**Taylor Wimpey
Colvedene Court
Wessex Business Park
Colden Common**

Your Ref :
Our Ref : AL/83/18/NMA

Section 96A of the Town & Country Planning Act 1990 (as amended)
Town and Country Planning (Development Management Procedure) (England) Order 2015 (as amended) - Article 10
Non material amendment following the grant of AL/102/17/RES for amendment to carports for plots 27, 207 & 208 & addition of garage door to each of the 9 No. carports.
Nyton Nursery, Nyton Road, Westergate,

WSC-A-4673-A-PT22-21B

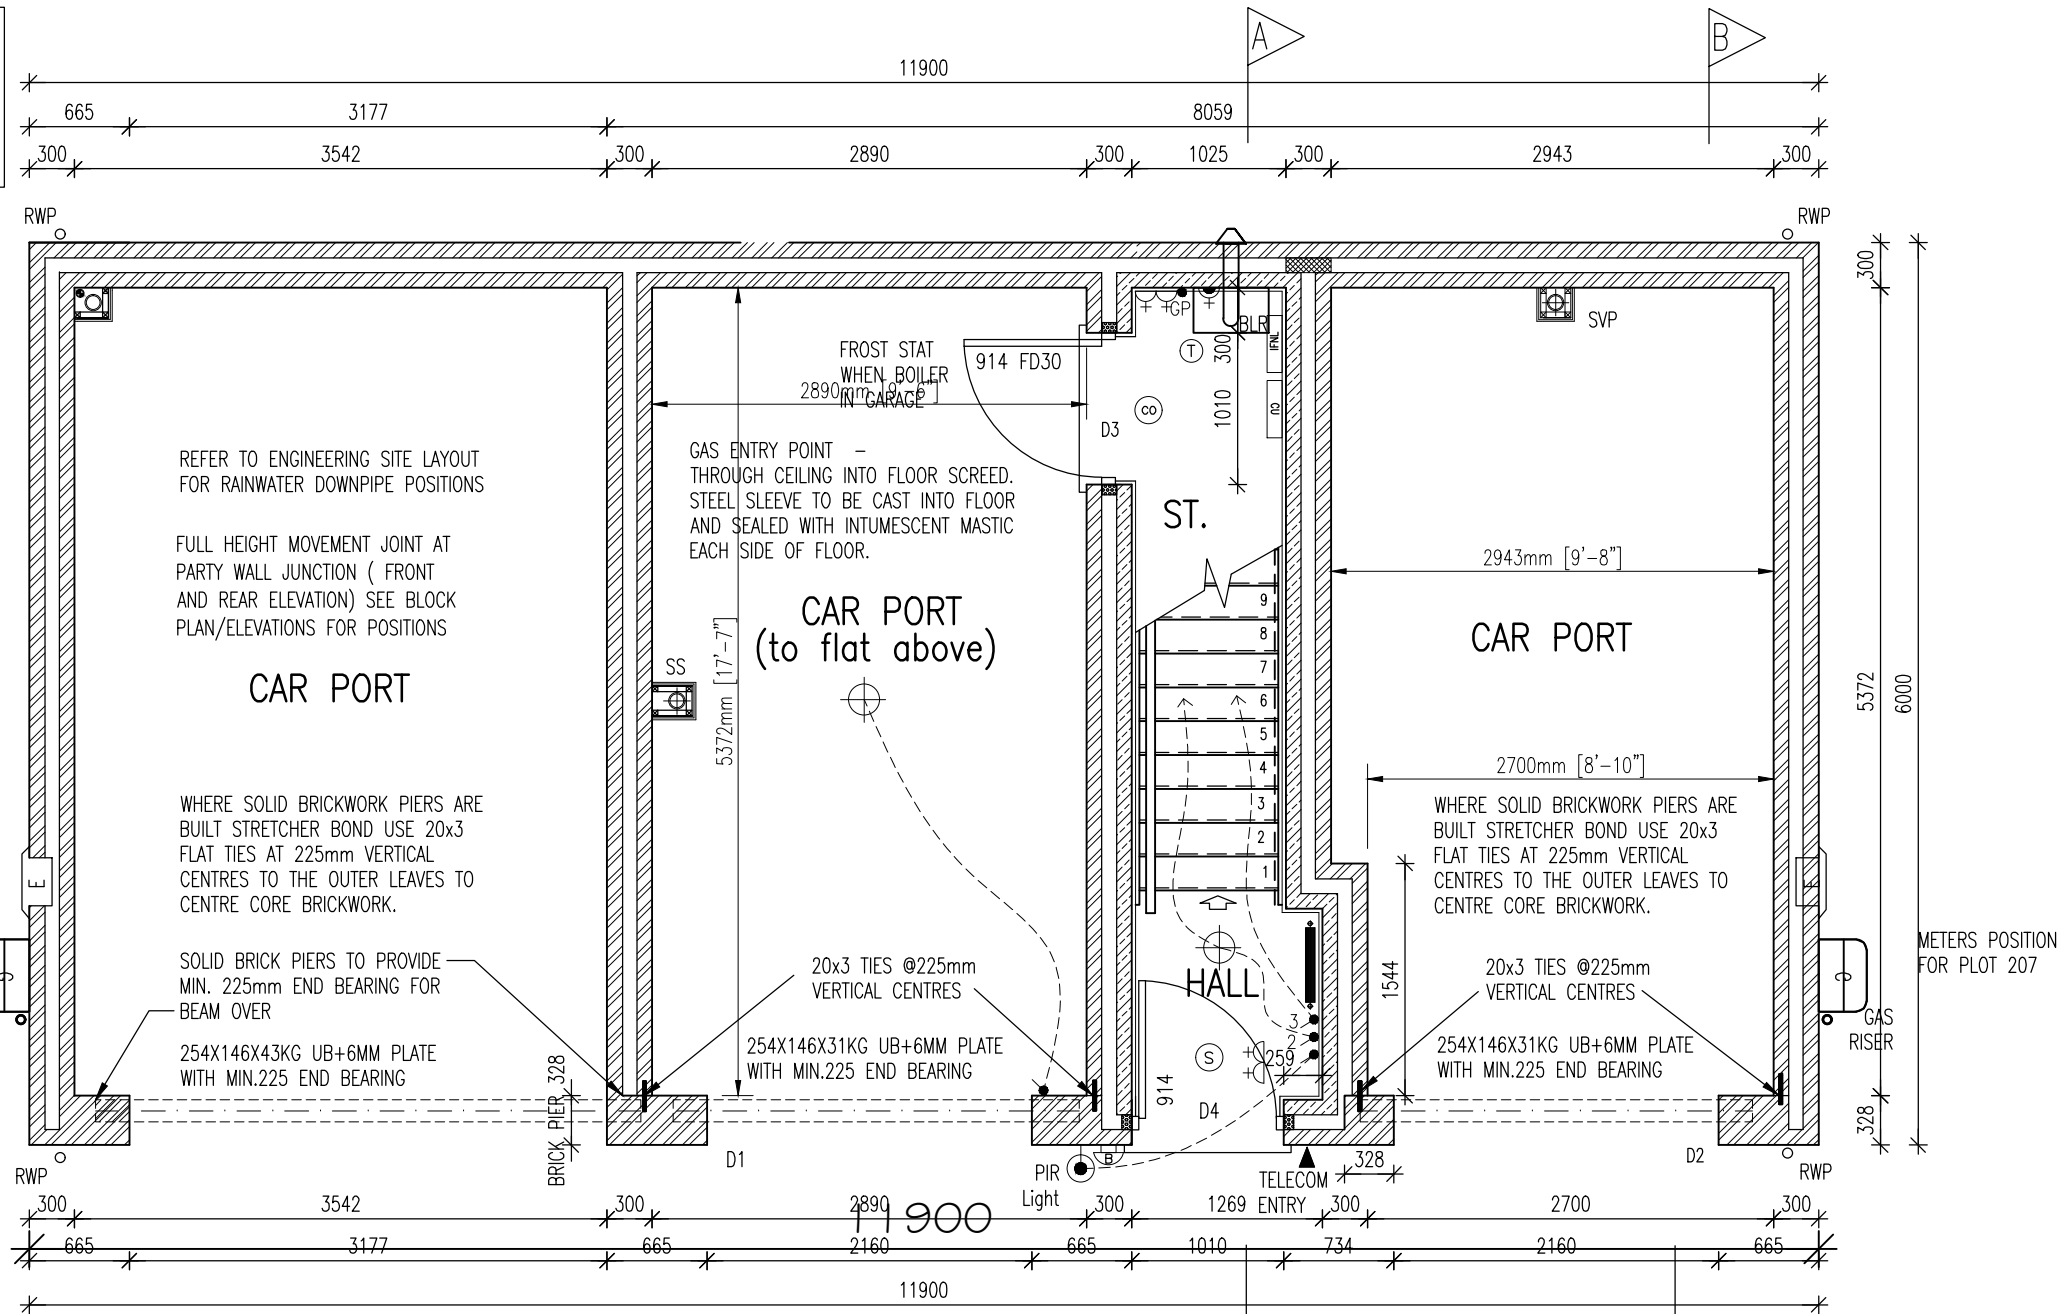
- Addition of garage doors to plots number 27, 207 and 208 to each of the 9 car ports; and
- Amendment to ground floor garage arrangements with access to services cupboard altered.

Therefore, drawing no. 'LHG 59650-115 Rev B' (House Type Plans and Elevations PT22 (Edale) Plot 27, 207, 208 as shown) replaces 'WSC-A-4673-A-PT22-21B' (House Type PT22 Ground Floor Plan) and 'WSC-A-4673-A-PT22-30A' (House Type PT22 Elevations), 'WSC-A-4673-A-PT22-31' (House Type PT22 Elevations) as the approved plans for AL/102/17/RES.
